Our Ref: TRIM No 006141.2012
Contact: Venetin Aghostin 9821 9357
Email: v.aghostin@liverpool.nsw.gov.au

Re: Exhibition of modification request for Dick Smith Distribution Warehouse (10_0010 Mod 2)

### *Sign 07 – South Face of Building*

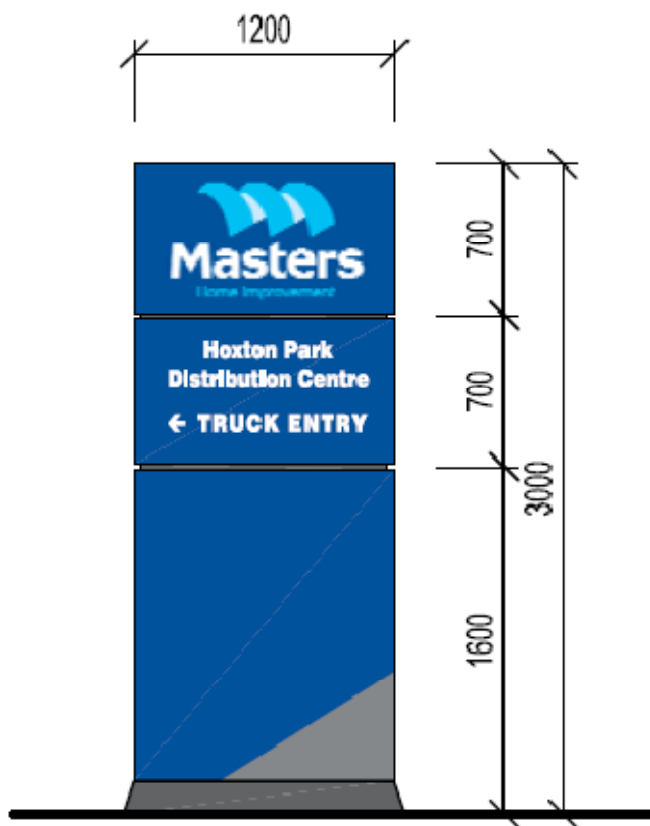
3. On a minor note, the wording of the signage refers to the "Hoxton Park Distribution Centre" however the locality is known as the "Len Waters Estate". As such, wording of the signage should be amended to reflect the correct locality.
4. It is requested the Department give due consideration and assessment of the environmental impacts of the additional use including, but not limited to, the quantities of chemicals stored at any one time; appropriate storage of any chemicals; and appropriate waste disposal.
